RE: 6/2021/0505/COND – H R Owen, Mosquito Way, Hatfield, AL10 9WN

Thank you for your consultation in relation to the above planning application for the Submission of details pursuant to conditions 1 (construction management plan), 2 (surface water drainage) and 7 (details of foundation design of approval) on planning permission 6/2019/1411/MAJ at H R Owen, Mosquito Way, Hatfield, AL10 9WN.

We advise the LPA that the information submitted in support of condition 2 in relation to surface water does not comply with the requirements set out in condition 2. Therefore, we recommend to the LPA not to discharge condition 2.

Drawn	Date	Checked	Scale @ A1
RGH	FEB 2019	MRW	1:500
Job No	Drawing No	Revision	Note
2018-22	S-001	C

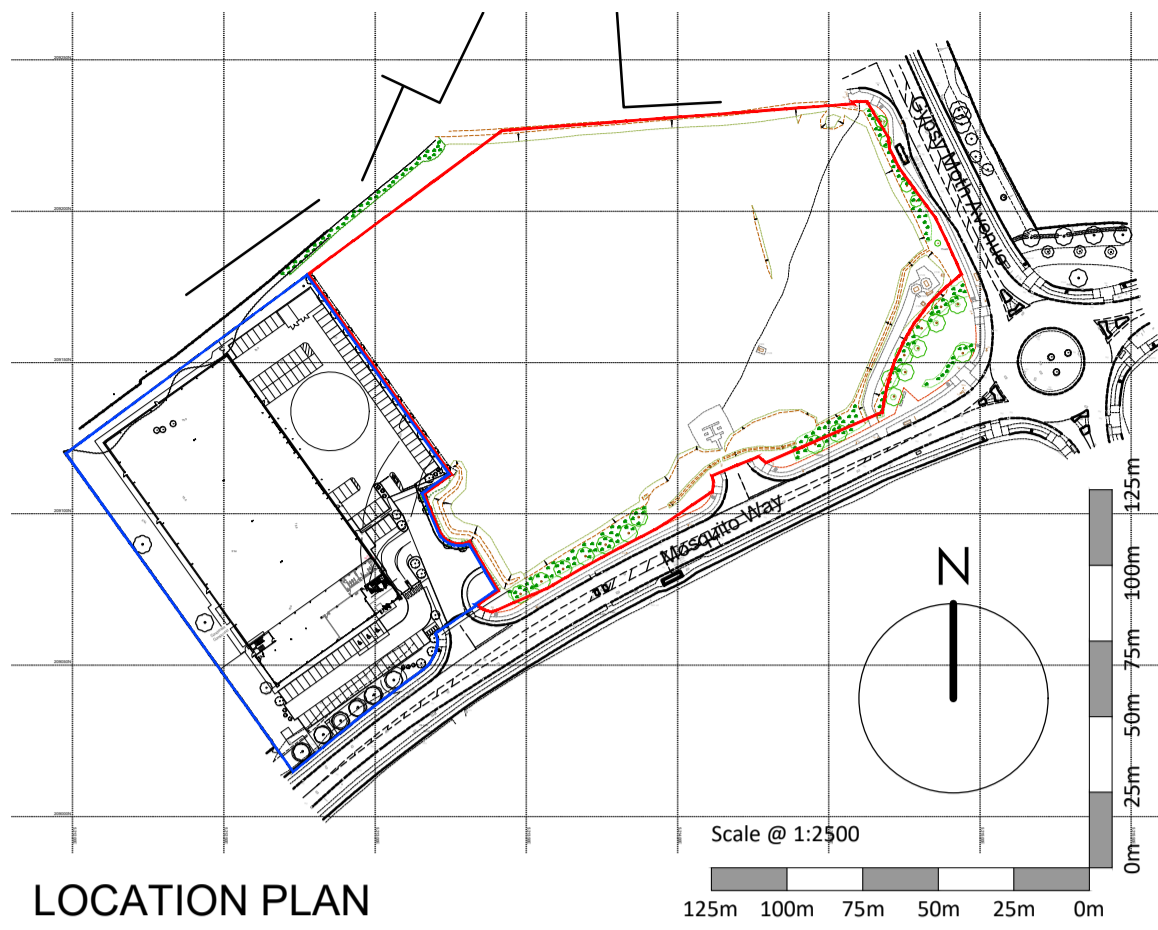
An updated drainage layout has been provided. It seems like the latest drainage strategy drawing does not fit with the submitted Location and Block Plan drawing number S-001 revision C, which in our understanding is the latest layout plan proposed. Therefore, the applicant should clarify that.
